From: Billington and Langho Parish Clerk <blparishclerk@outlook.com>
Sent: 12 December 2020 18:26
To: Planning
Subject: 3/2020/1022

3/2020/1022

Proposed Site Plan
 Scale (1:500)

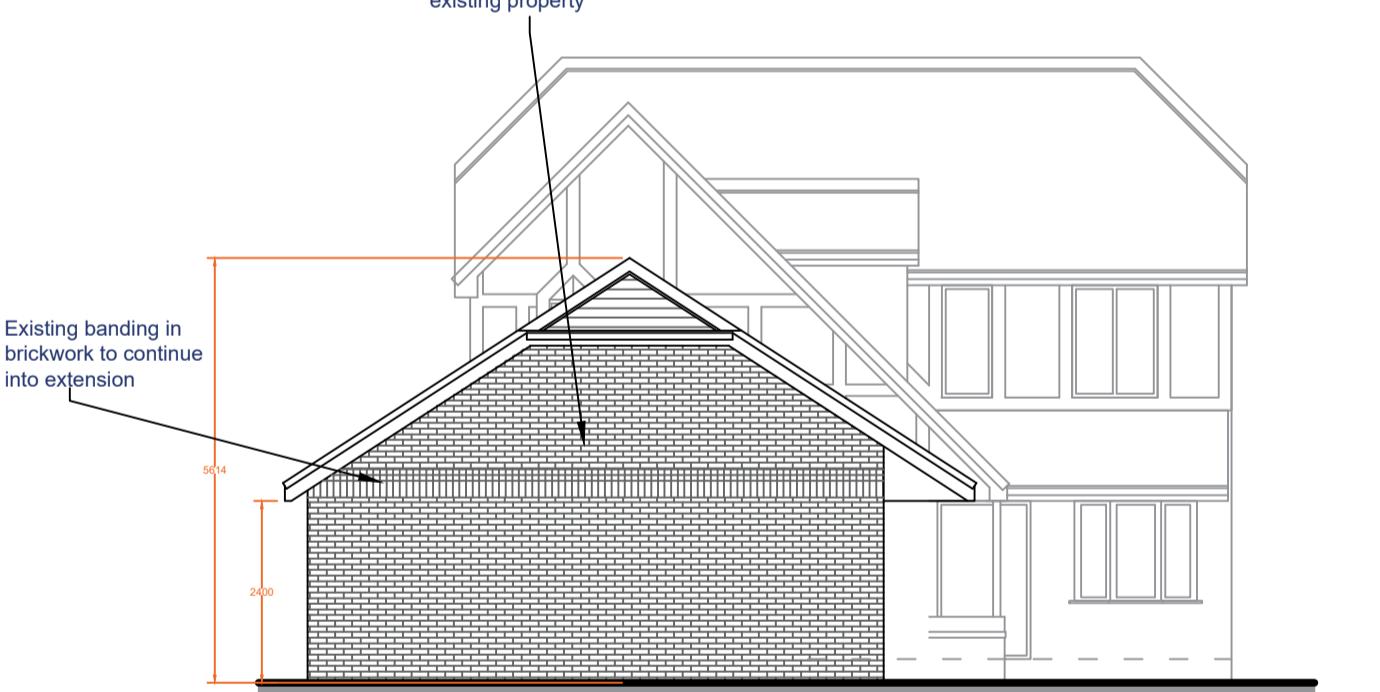
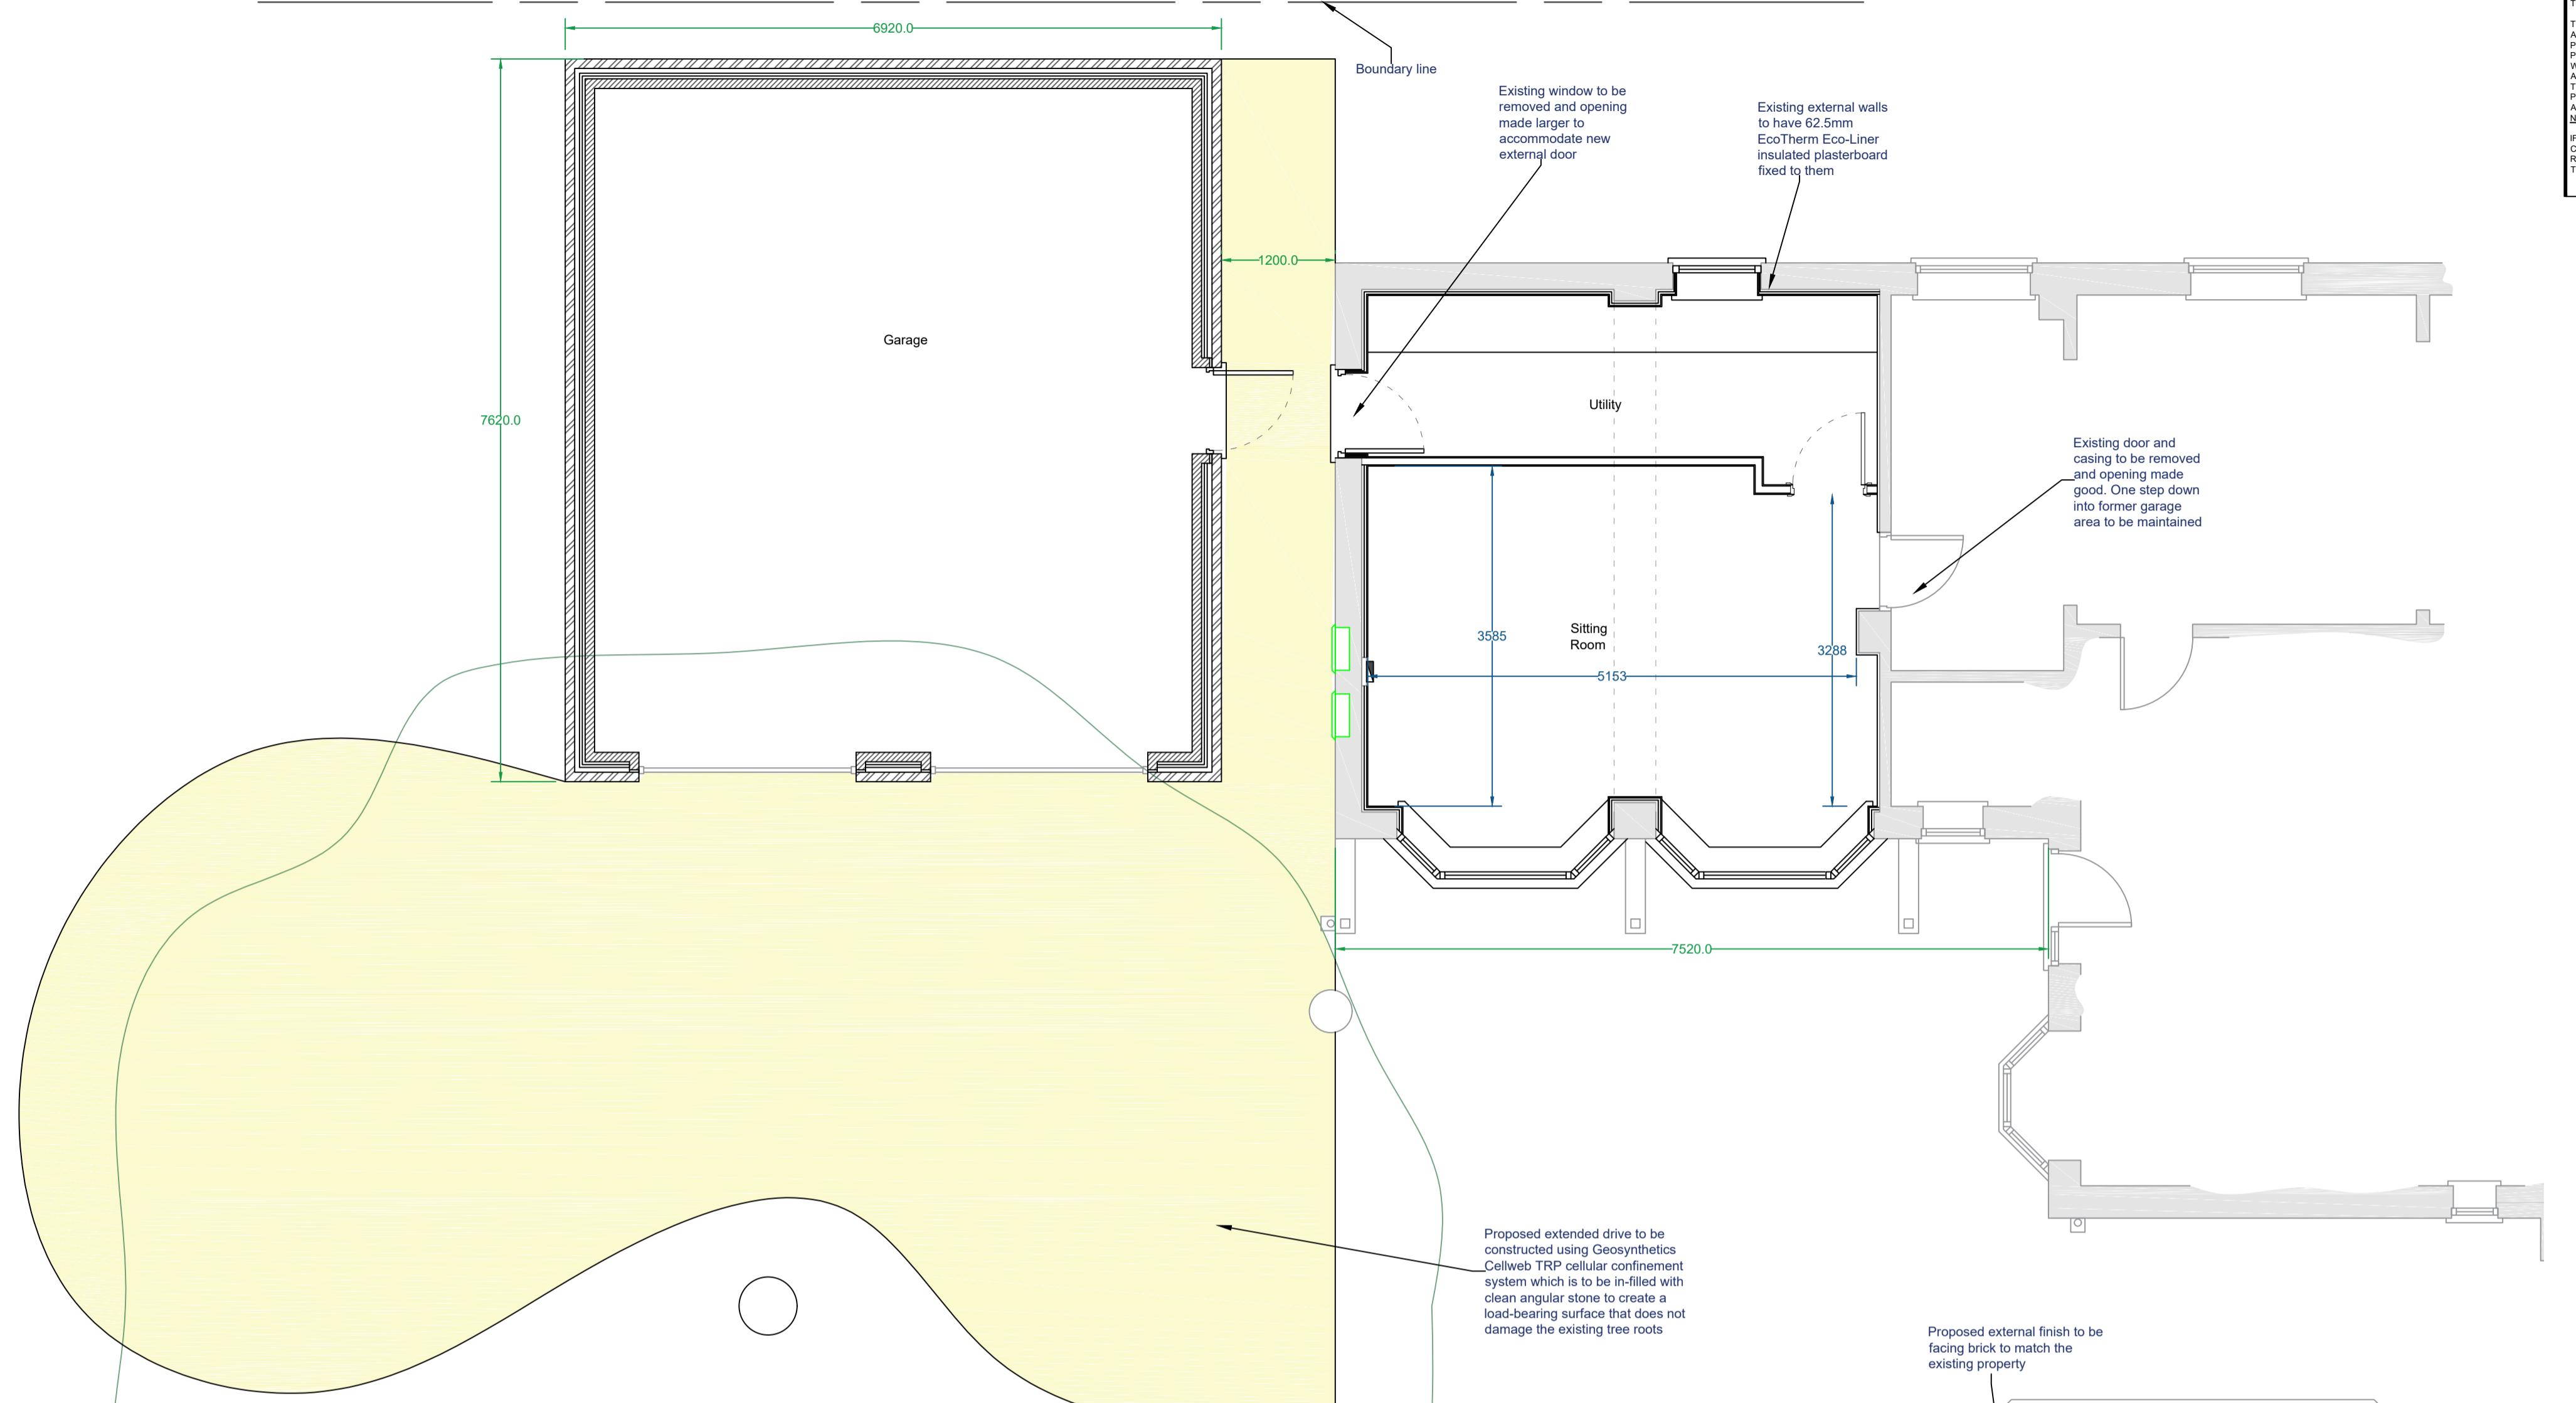
After consultation with all members of the parish council concerns were raised regarding the vicinity of the trees to this application. There are two substantial trees and questions were asked as to potential TPO's for them.
